Demolition & erection of 1 No. dwelling with swimming pool.
Little Deerswood Gorse Avenue East Preston

Thank you for your internet representation made on 27th August 2018 which has been recorded as '**an objection**' with the comments as follows:

I am commenting on this application on behalf of the East Preston and Kingston Preservation Society.

South & West Elevations as proposed

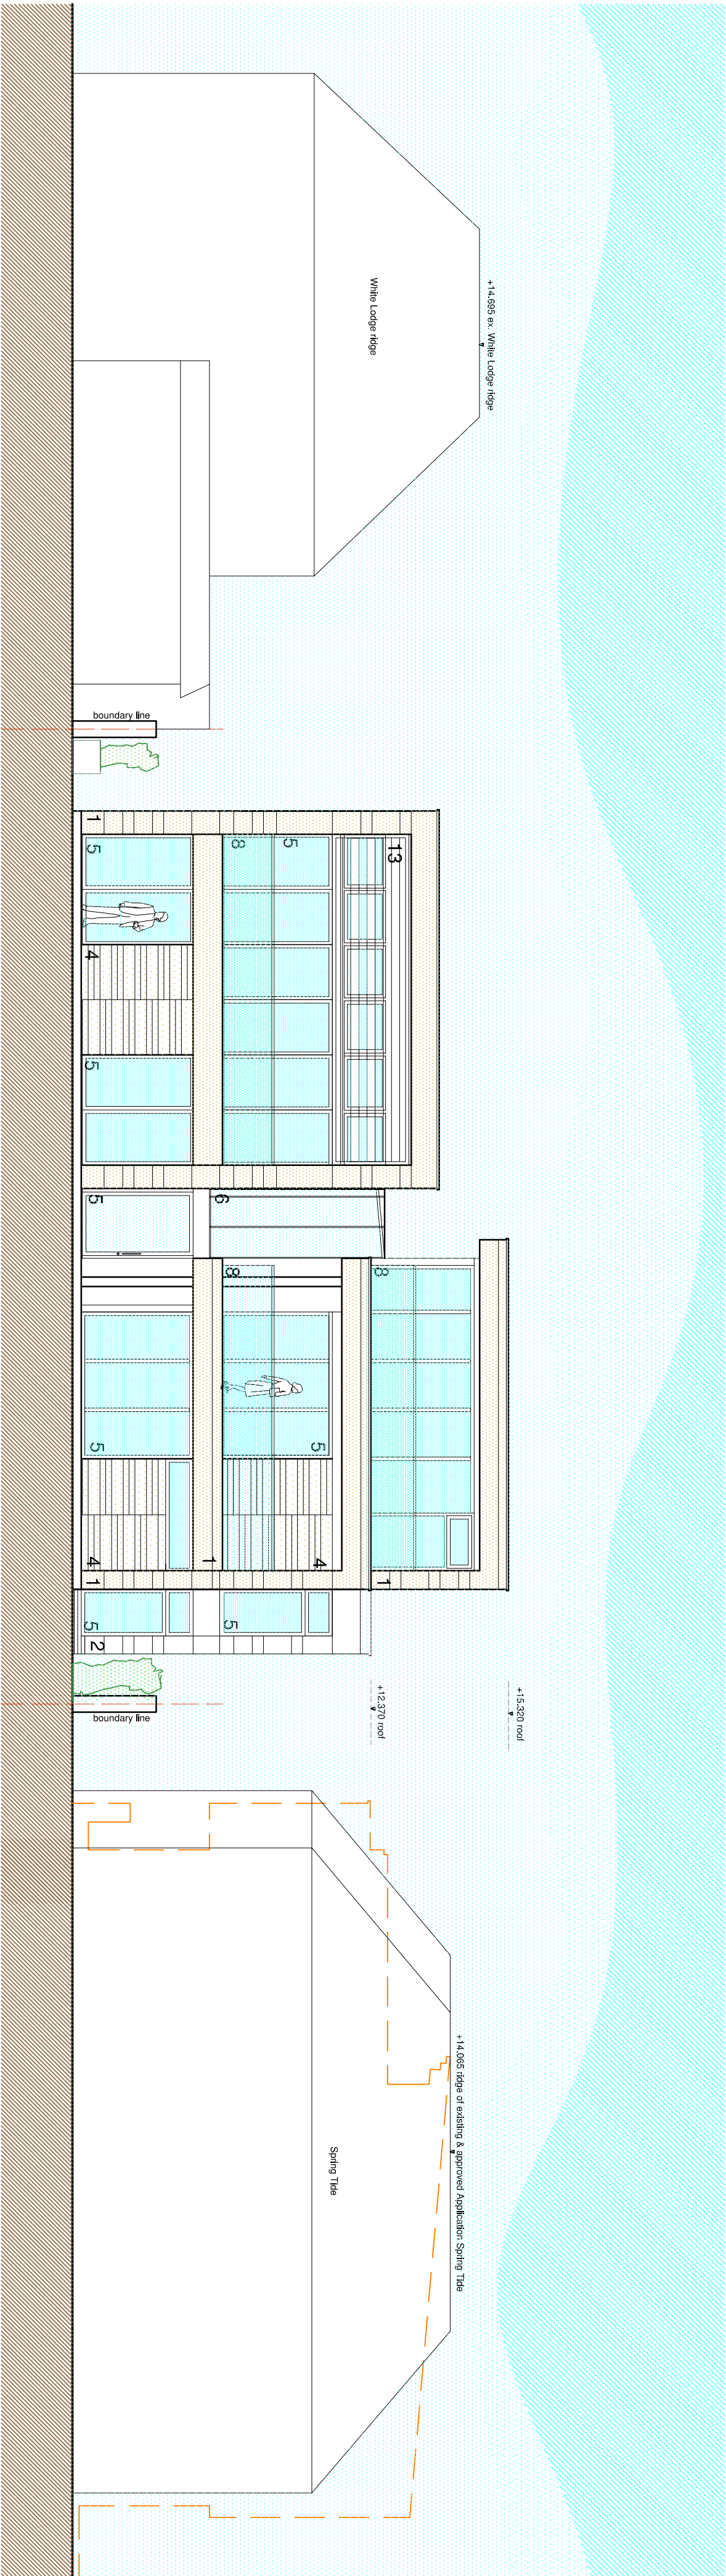
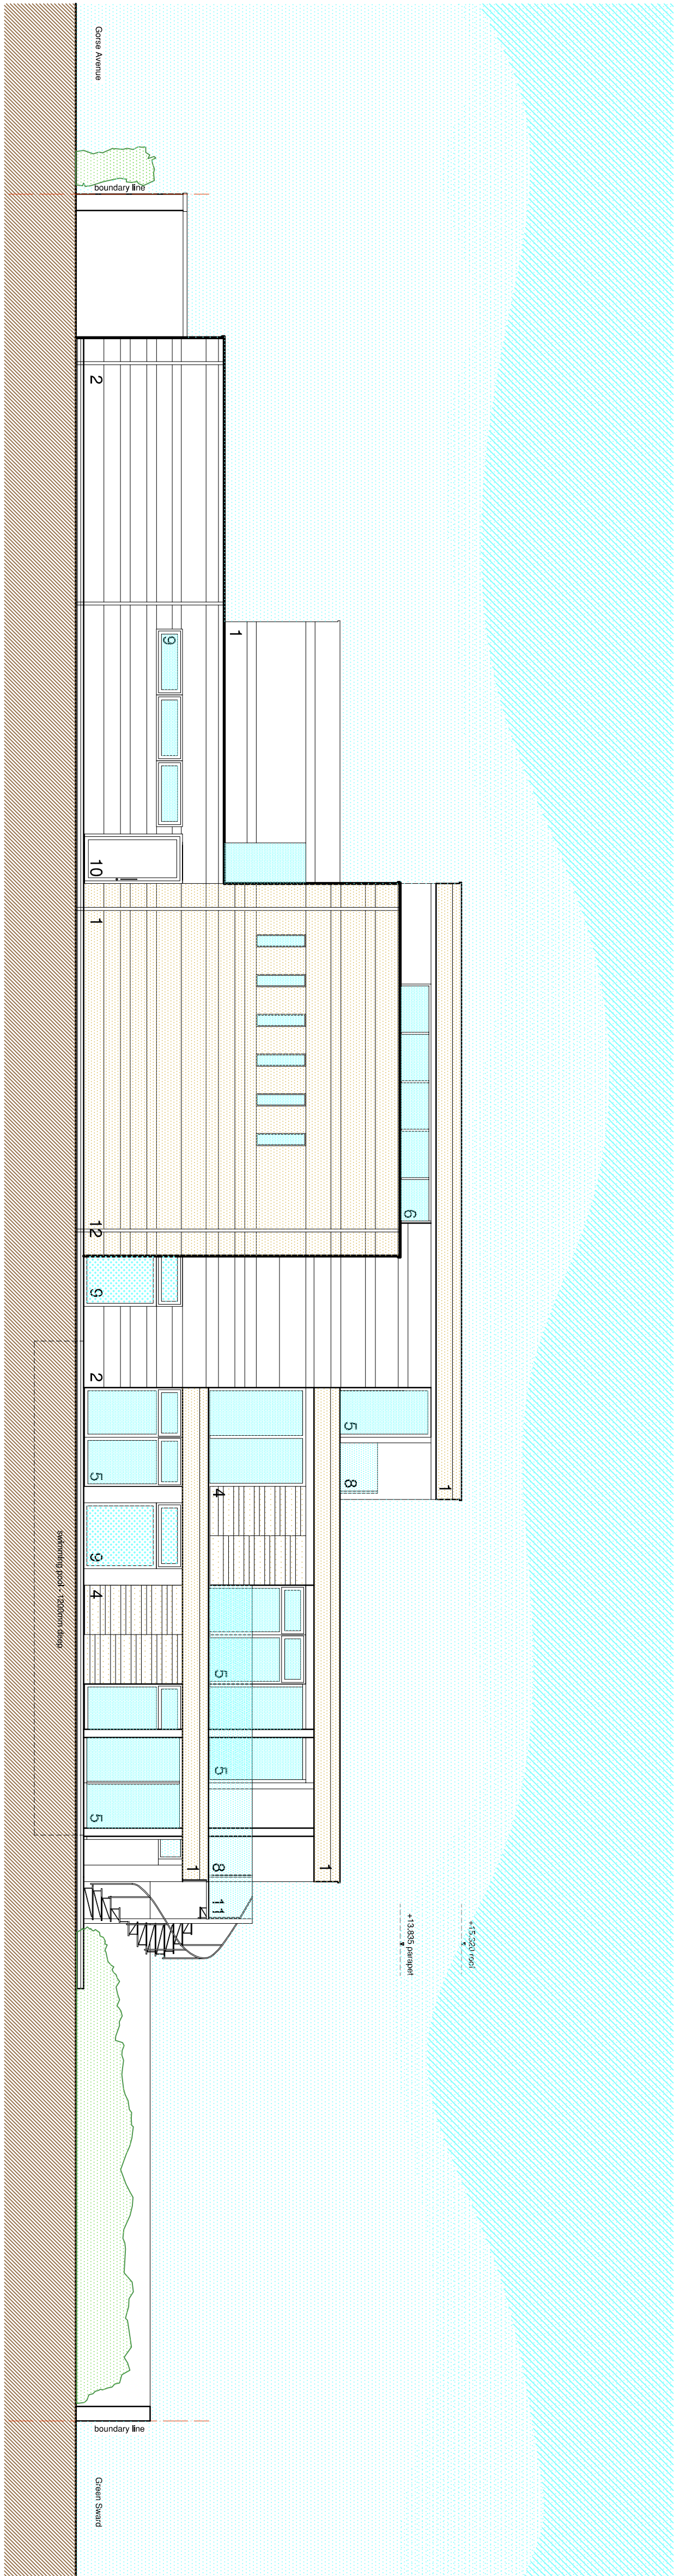
This application represents an insensitive attempt to insert a large house into a narrow site. As a flat roofed three storey building, it is taller than its neighbouring two storey houses with pitched roofs. It would extend significantly south of the building line on the beach side of the site, and appears to have a number of windows in its western facade (which, significantly, is not shown specifically among the published plans) that would overlook the south facing windows and gardens of its western neighbours.
